LSC TRANSPORTATION CONSULTANTS, INC.
545 East Pikes Peak Avenue, Suite 210
Colorado Springs, CO 80903
(719) 633-2868
FAX (719) 633-5430
E-mail: lsc@lsctrans.com
Website: <http://www.lsctrans.com>

August 9, 2018

RE: Gardens at North Carefree
PUD-18-001
Noise Impact Study
El Paso County, Colorado
LSC #174311

**THE GARDENS AT NORTH CAREFREE
PRELIMINARY GRADING PLAN**

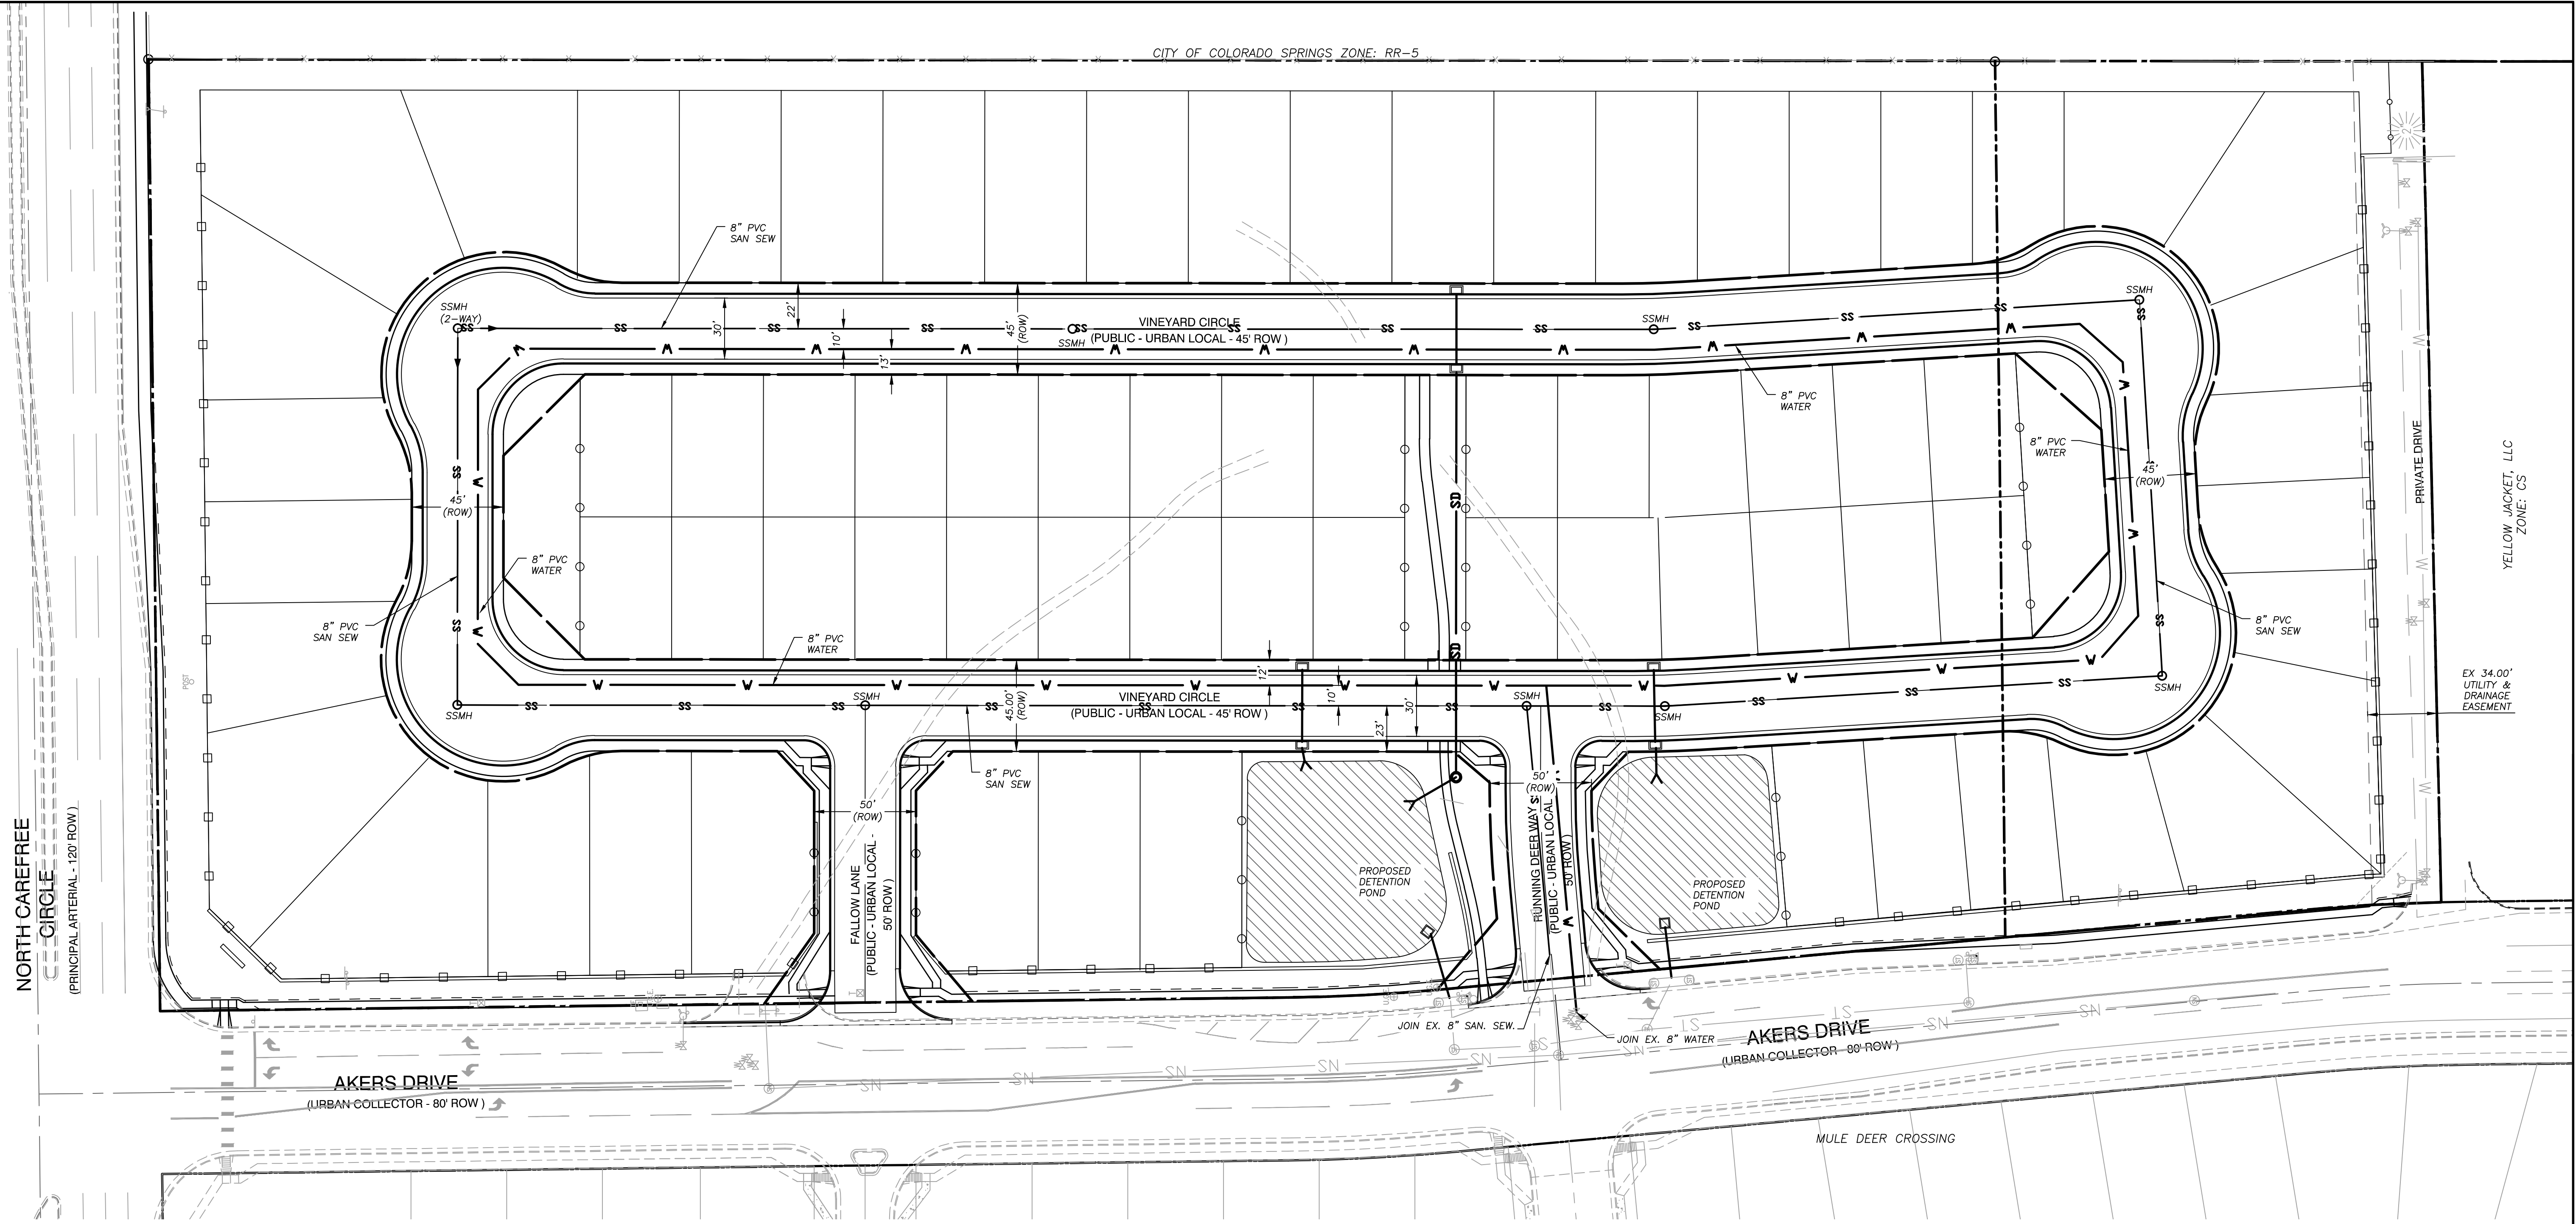
2. Callout the offset distance from the property line the receiver locations were modeled at. Per the grading plan the roadway slope extends past the property line. The receiver should be set back from the toe of the slope.
